Date: 28 June 2018
Your reference: SSD 6634
Our reference: DOC18/427484
Contact: Calvin Houlison
4224 4179

RE: SSD 6634 Sutton Forest Quarry Project – Comments on EIS

ATTACHMENT A – OEH DETAILED COMMENTS SUTTON FOREST QUARRY PROJECT EIS – SSD 6634

Appendix 1 Figure 1

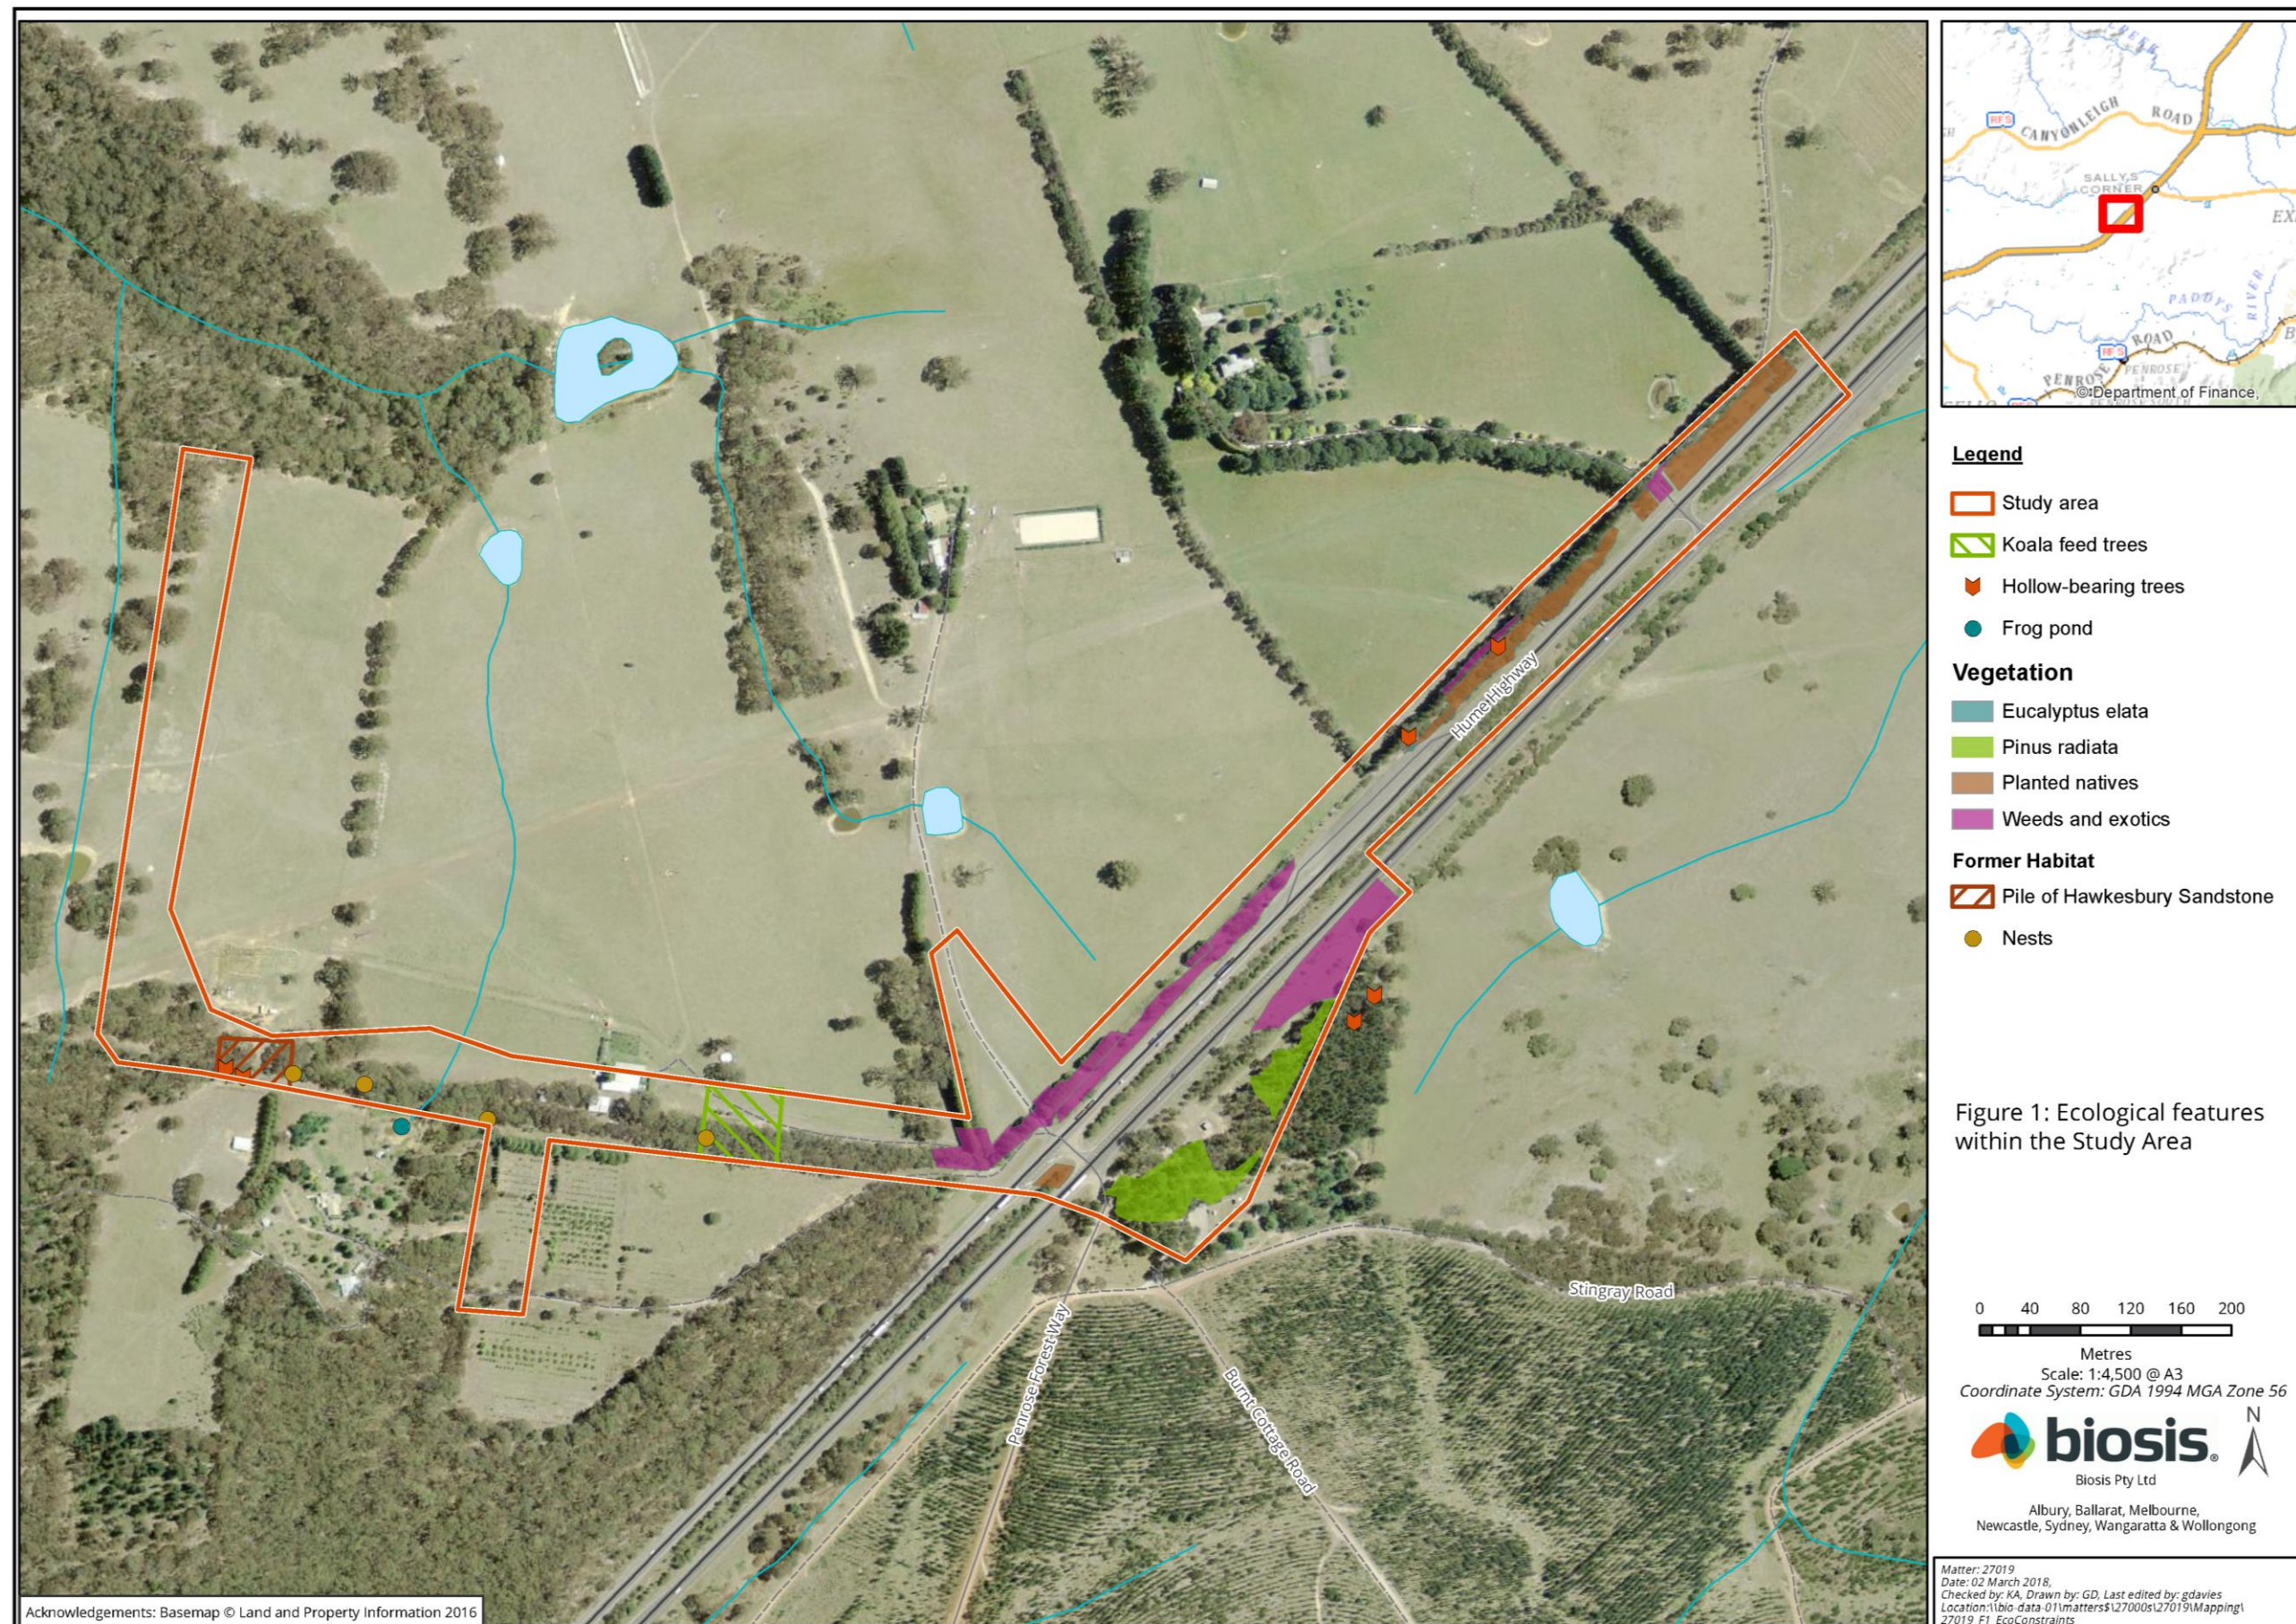
Based on the surveys of hollow-bearing trees (HBTs) undertaken (Figure 1), we question whether the locations surveyed accurately reflect the full extent of HBTs on-site. We also question whether areas in the western and northern parts of the site were surveyed as this area shows a distinct lack of records in comparison to the cluster of HBTs indicated.

Hollow-bearing trees are a key habitat feature for a variety of threatened and non-threatened species and removal of these trees is difficult to mitigate or offset given the time it takes for hollows to form. Given the large number of hollow-dependent threatened fauna species recorded in the impact area, within a 10km radius of the site, or with habitat in the impact area, we consider that a comprehensive assessment of hollow-bearing trees in all areas proposed to be impacted is required.
